Application No: 18/00039/DISC-3 – REVISED RESPONSE

Proposal: Discharge of condition 19 (materials and finishes), 23 (bus stops), 59 (Construction

Amended details of bus stops (for condition 23).

Location: Bicester Eco Town, Exemplar Site, Banbury Road, Bicester.

Title: SPINE ROAD (S38) GENERAL ARRANGEMENT SHEET 1 OF 4

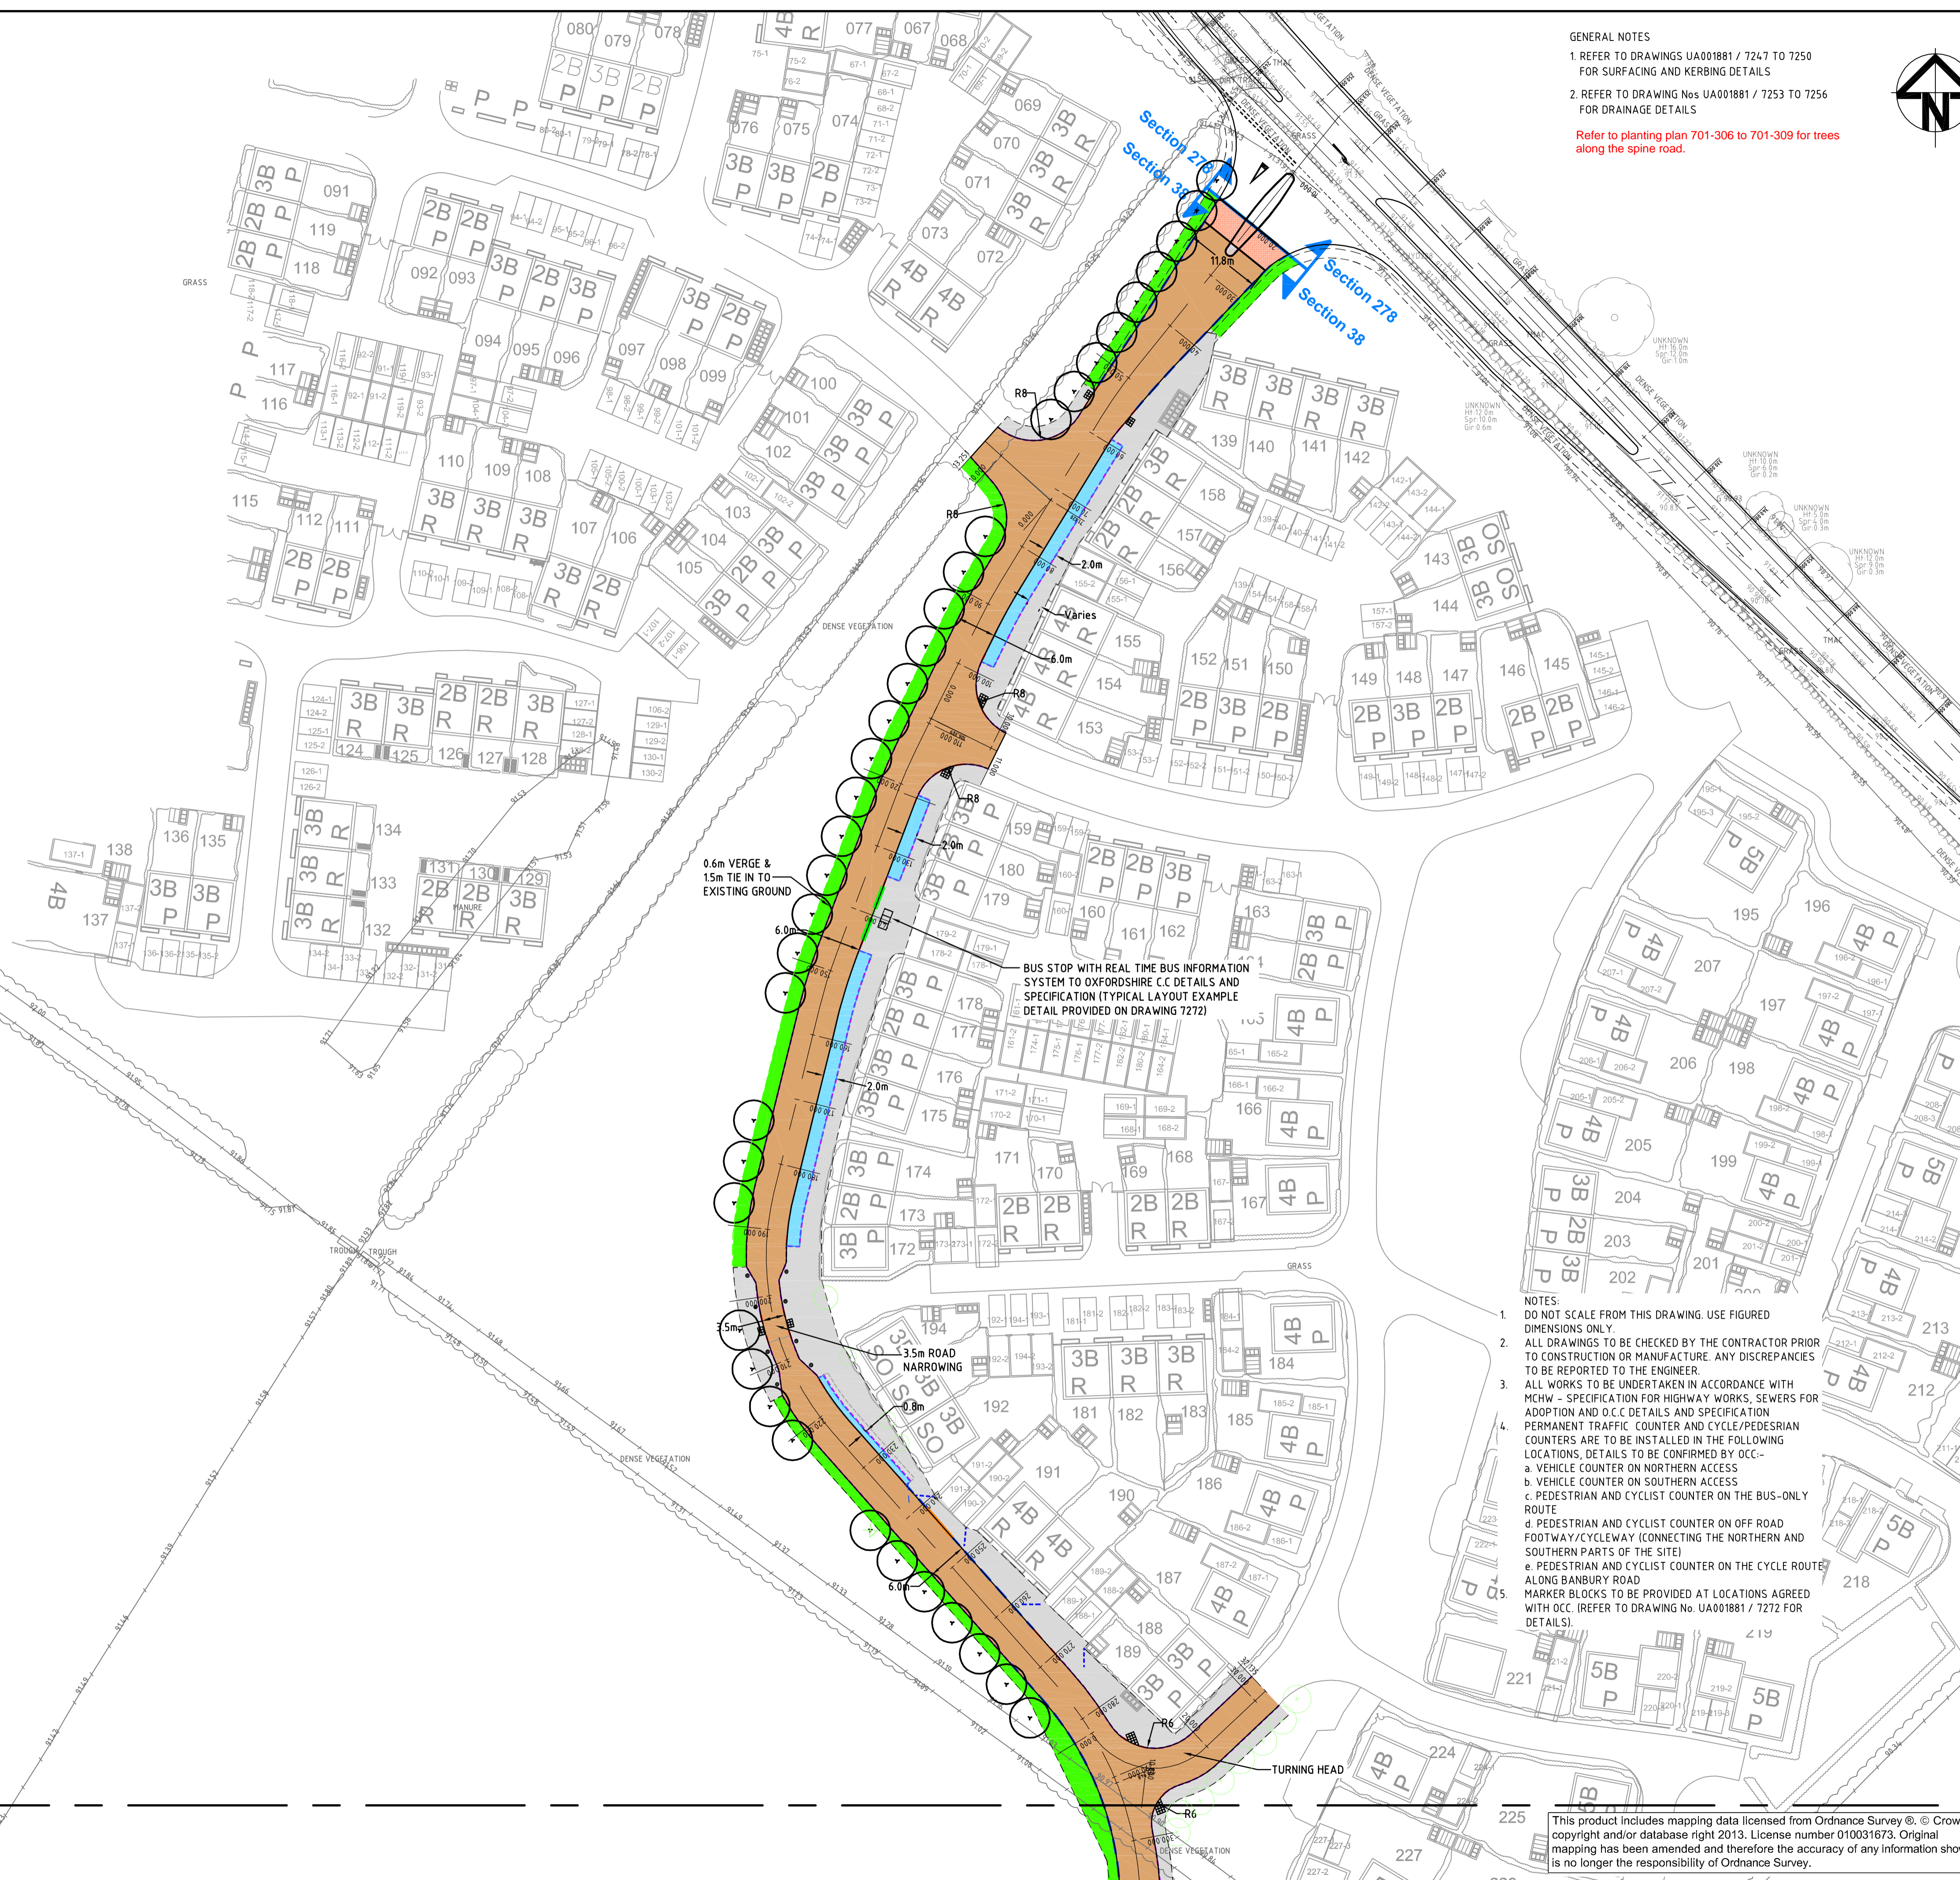
Detailed comments: The bus stop details as shown on the layout plans, and the flagpole display details provided, are acceptable.
